DEVELOPMENT HEARING OFFICER

PR-2019-002663

SD-2024-00097

REQUEST: CREATE 6 NEW TRACTS FROM ONE EXISTING TRACT

**Plat for**  
**Tracts 1-A-1 thru 1-A-6, Block 2,**  
**Volcano Cliffs Subdivision, Unit 26**  
*Being Comprised of*  
**Tract 1-A, Block 2, Volcano**  
**Cliffs Subdivision, Unit 26**  
*City of Albuquerque*  
**Bernalillo County, New Mexico**  
**May 2024**

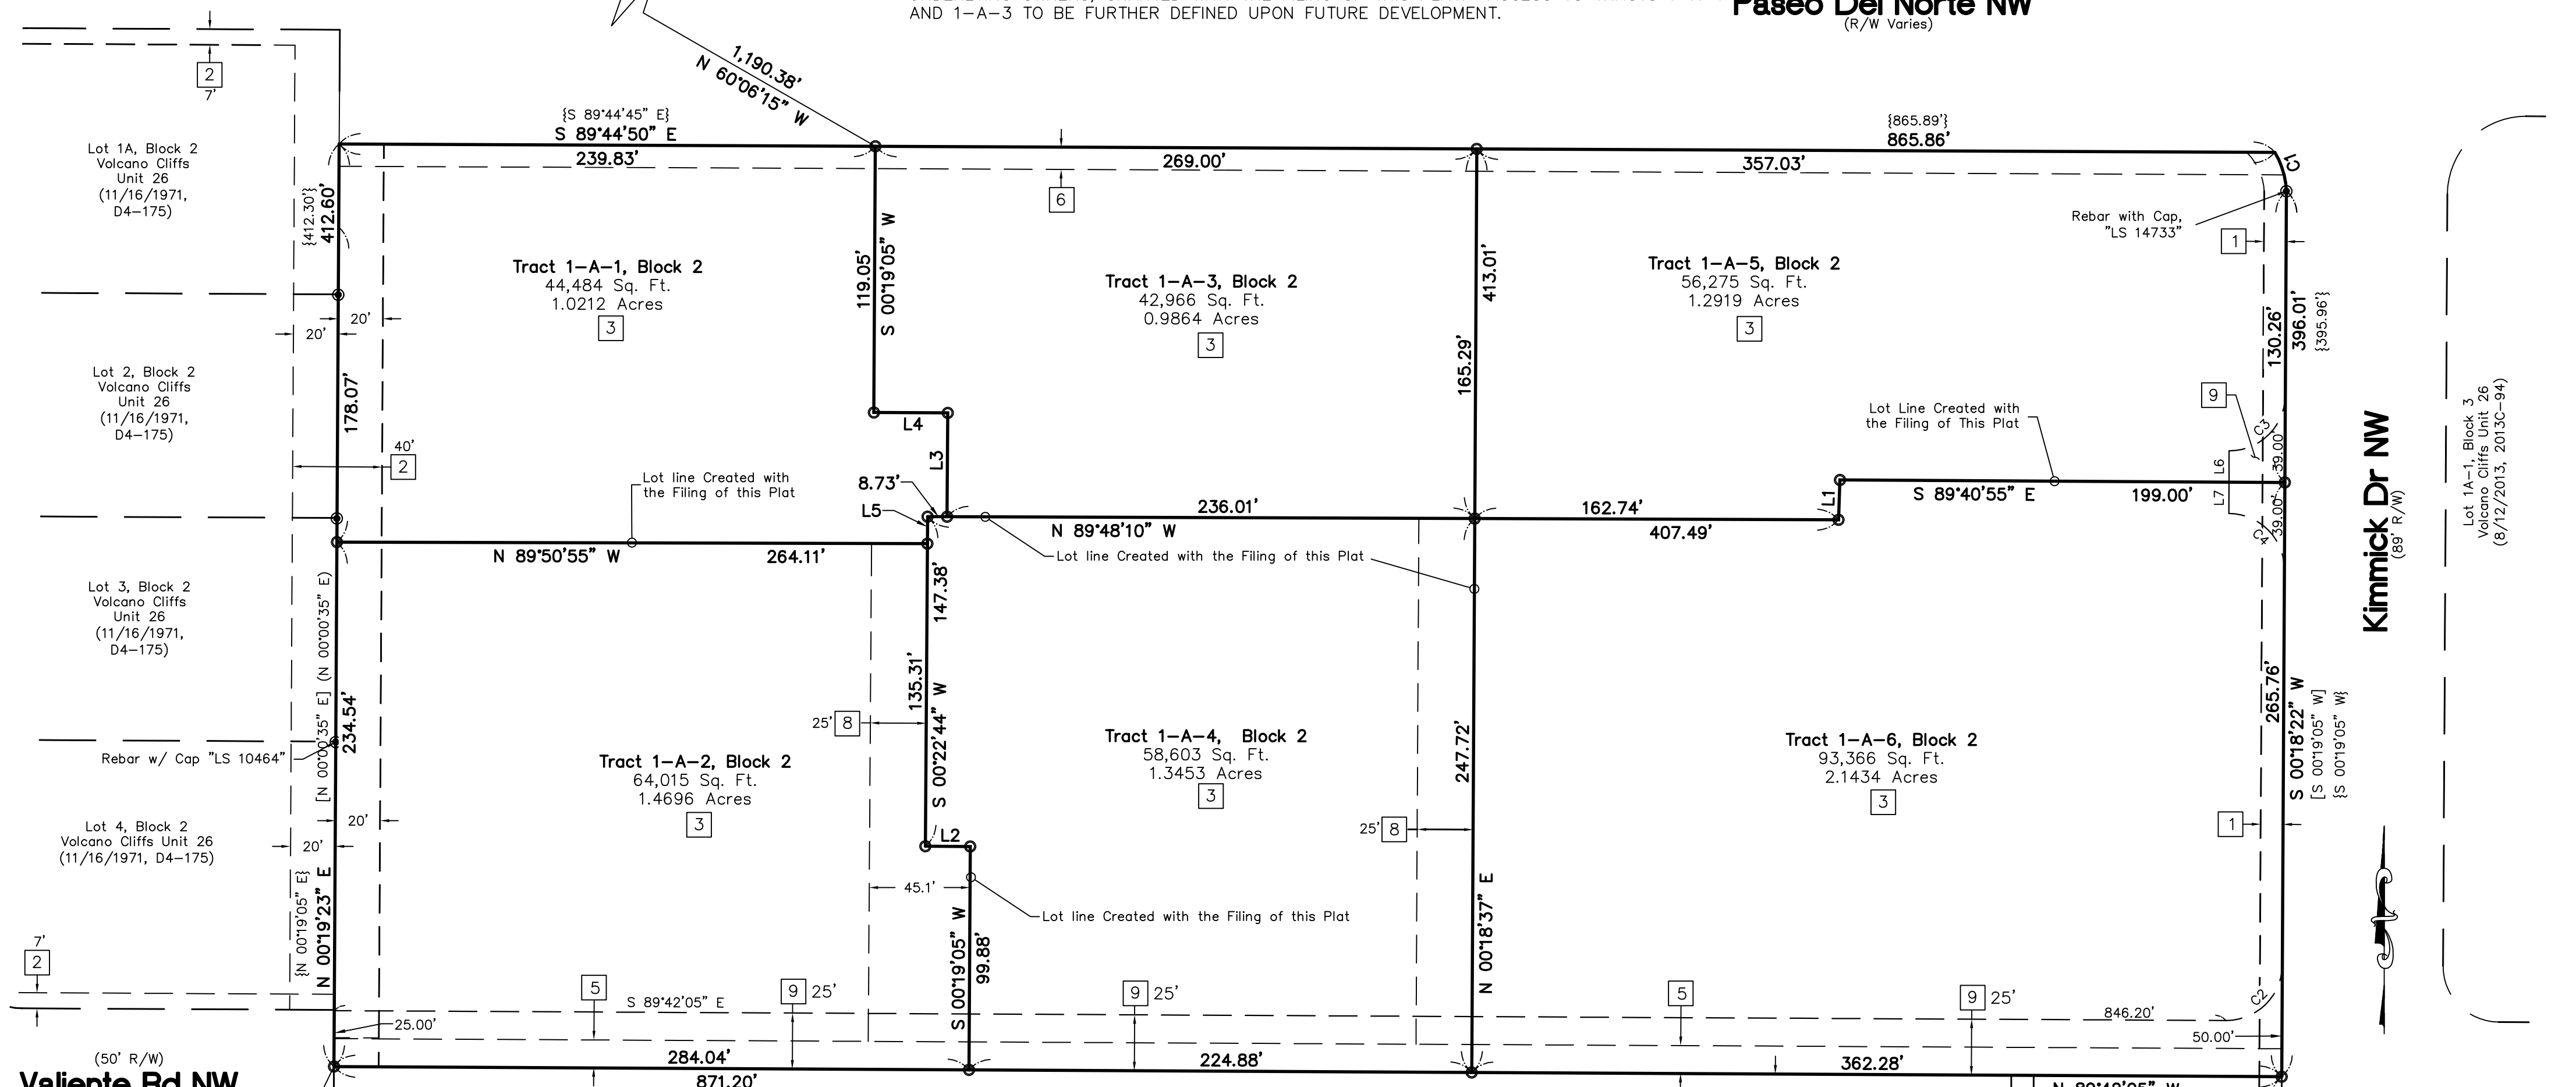
1. Easement note 8 is listed as a public waterline easement on the first page and a private water and private sewer easement on the second page. Please clarify.

Is the proposal for this plat to dedicate ROW for the north half of Valiente? The previous plat and site plan for the southern tract shows the southern half of Valiente as a private drive. Please reconcile this difference. Also, reconcile a private street leading into a public street west of the subject parcel.
